ASM Engineering, PLLC

October 2, 2023

Re: 158 Edgemont Terrace
Sanford, NC 27332
ASM# 23053

ASM Engineering, PLLC (ASM) performed an inspection at the above referenced site on September 14, 2023. The purpose of the site visit was to inspect the rafters on a newly covered back patio.

ROOF SECTION  
Scale: 1/4" = 1'-0"

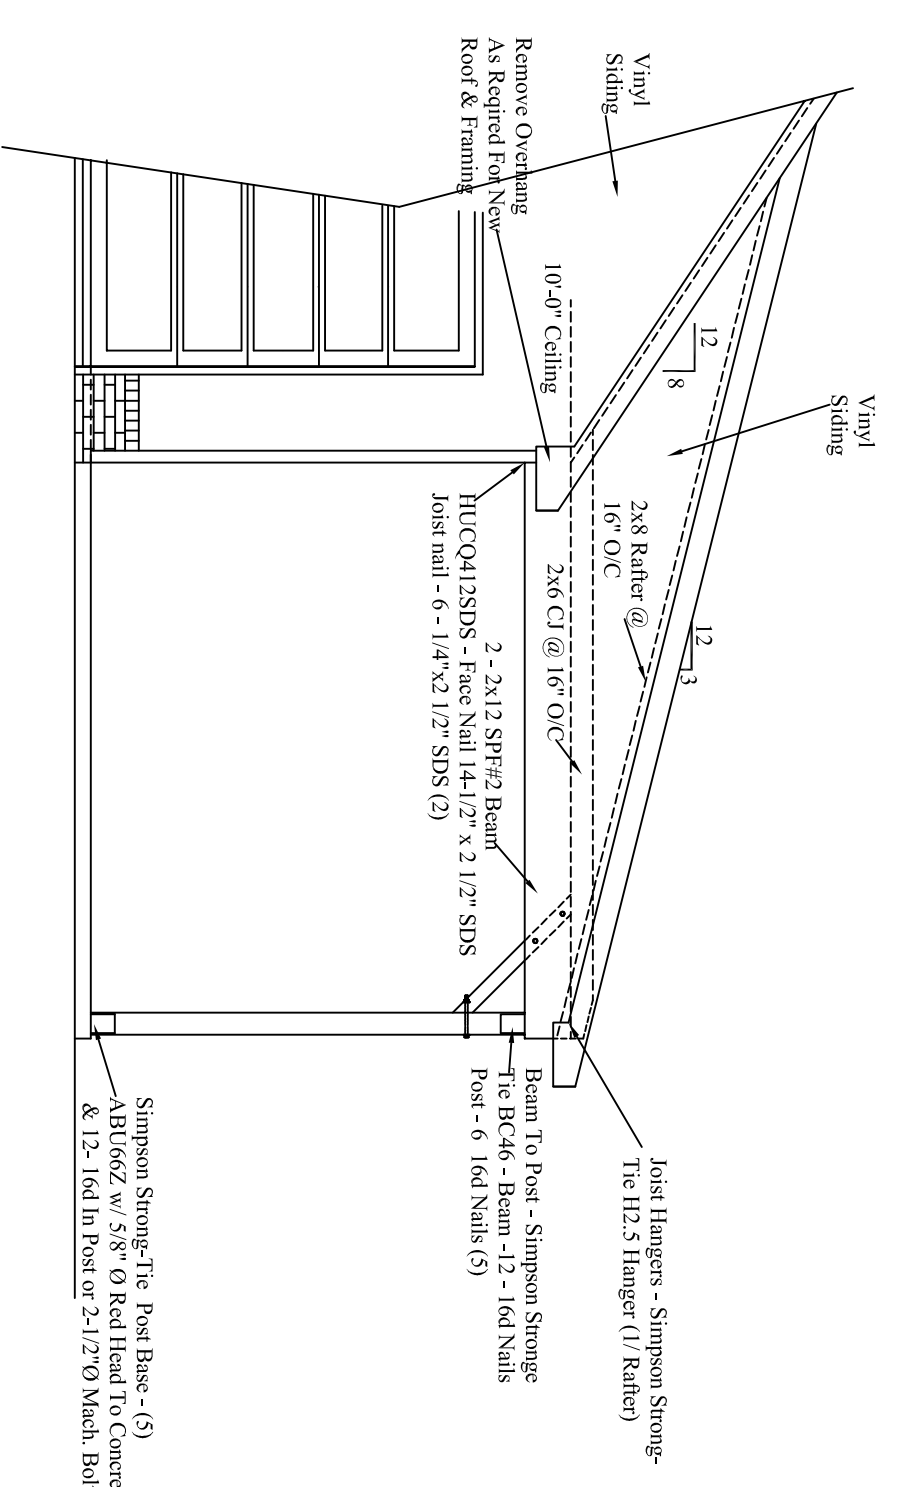
At the time of the inspection, the patio was covered and the framing was complete. The area of concern was the rafter depth size at the bearing location furthest away from the house (See Figure 2.0). According to the NC 2018 Residential Building Code, the required rafter depth at the outside bearing location is required to be a min. of 3-1/2" in depth (See Figure 3.0). The rafters were measured and found to exceed this min. depth of 3-1/2", and therefore meets the requirements of Chapter 8, from the NC 2018 Residential Building Code.
